ZIBI BLOCK 204 HIGH-RISE CONDOMINIUM

DESIGN BRIEF
SITE PLAN CONTROL (SPA) RE-SUBMISSION

315 MIWATE PRIVATE
OTTAWA, ON
PROJECT 12791
SEPTEMBER 15TH, 2022

Drawing file: plan / All_Image Referencing_Site Plan Application_Image Reference_2022-10-03 - Elevation-East - D07-12-22-0071.PDF

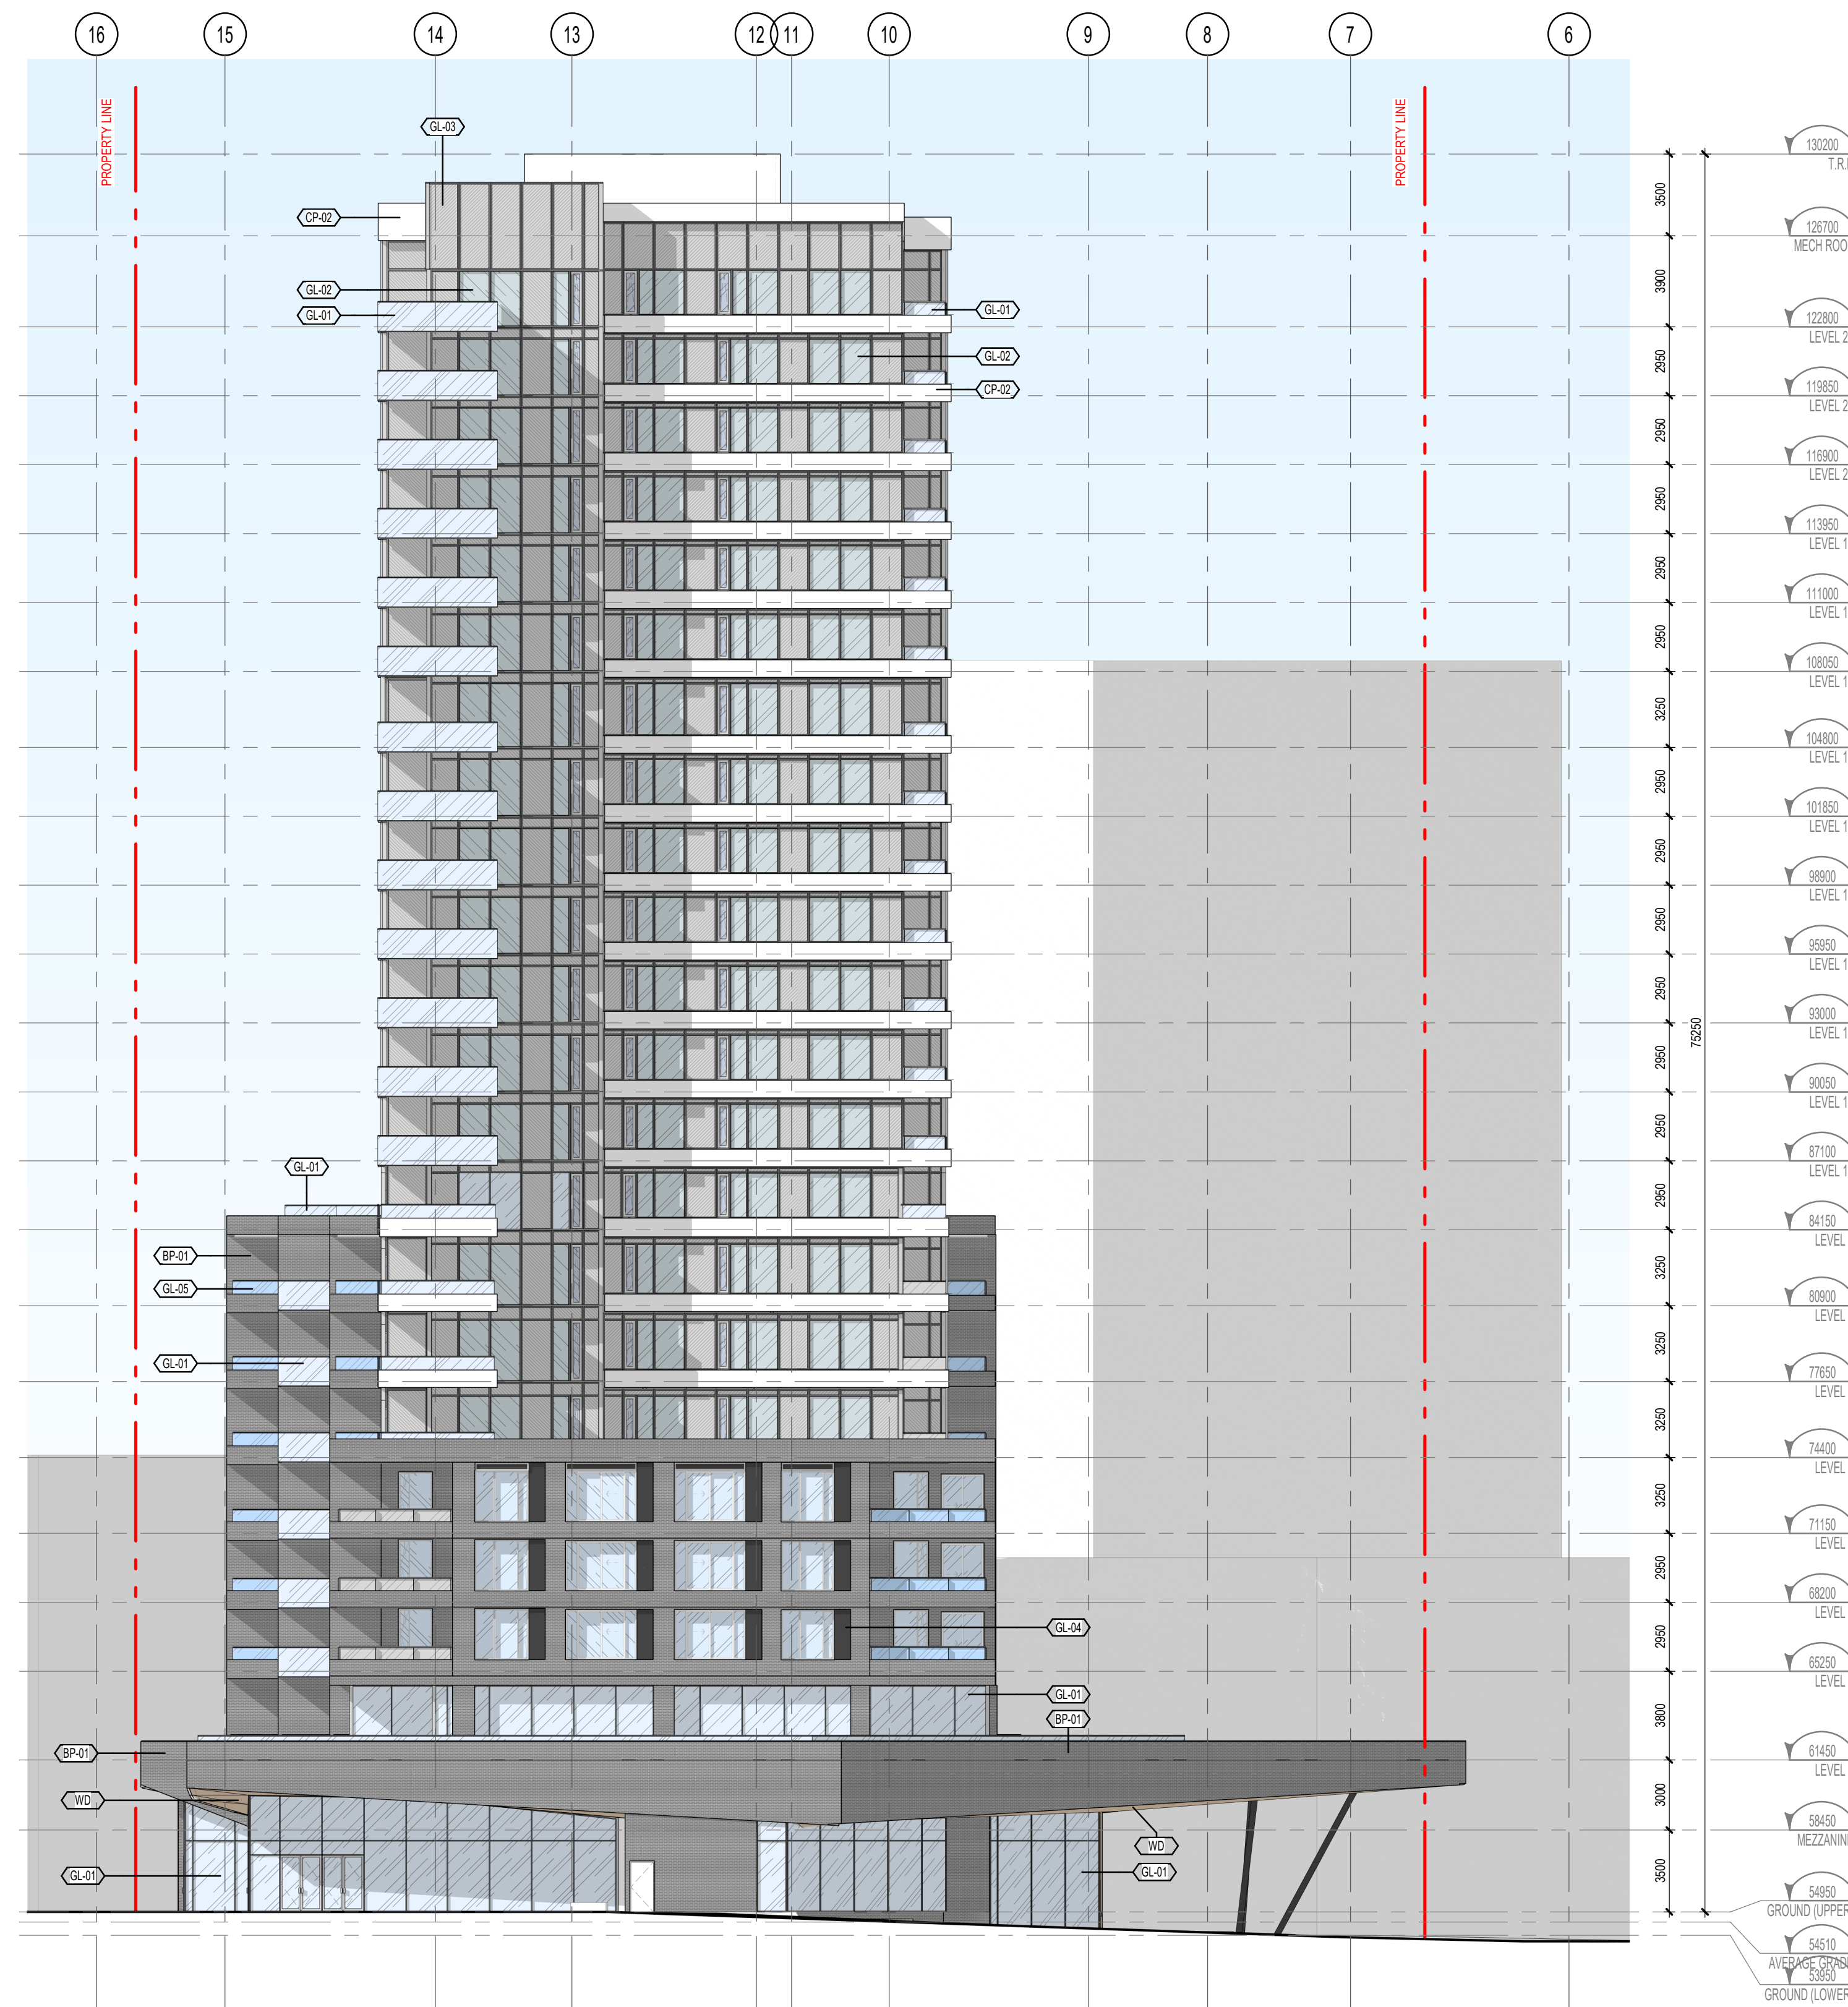
1. Podium Height - The proposed building should have a higher podium facing Head Street Square to better frame its western edge and provide a sense of enclosure and visual termination to the square and to match the heights of the surrounding buildings.
2. Materiality - The contrast between the black and white materials creates a complexity which the building may not need. The Panel recommends the proponent use a single material and a lighter coloration for the tower to knit better with the context and for the building to fade into the sky.
3. Ground Floor - The double base and the lower canopy podium facing the square lack human scale; the Panel believes a mid-rise base is more appropriate to create a street wall and sense of enclosure for the square and meet the one-to-one base-to-street ratio.

1. Podium Height - The revised design creates a wrap-around massing through the 5-8 storey podium, which provides an enclosing face to the square of the east side of the site.
2. Materiality - The coloration of the tower has been reduced to just white with cementitious bands highlighting each level. The use of glazed spandrel panels aim to create a softer transition between solid and opaque portions of the tower along the horizontal.
3. Ground Floor - The project team feels that the double-height ground floor with a roof terrace at Head Street Square provides the opportunity for an activated connection between the ground tenant and users of the residential outdoor space with the public realm. Further, by setting the podium and tower volume back, the design team feels this improves the pedestrian experience by minimizing the shadow effect on the square.

Taking into consideration the UDRP's comments on creating a stronger podium presence on Head Street Square, the revised design pushes out the eastern mid-podium volume to create a more gradual transition from the two-storey ground floor to the tower volume.
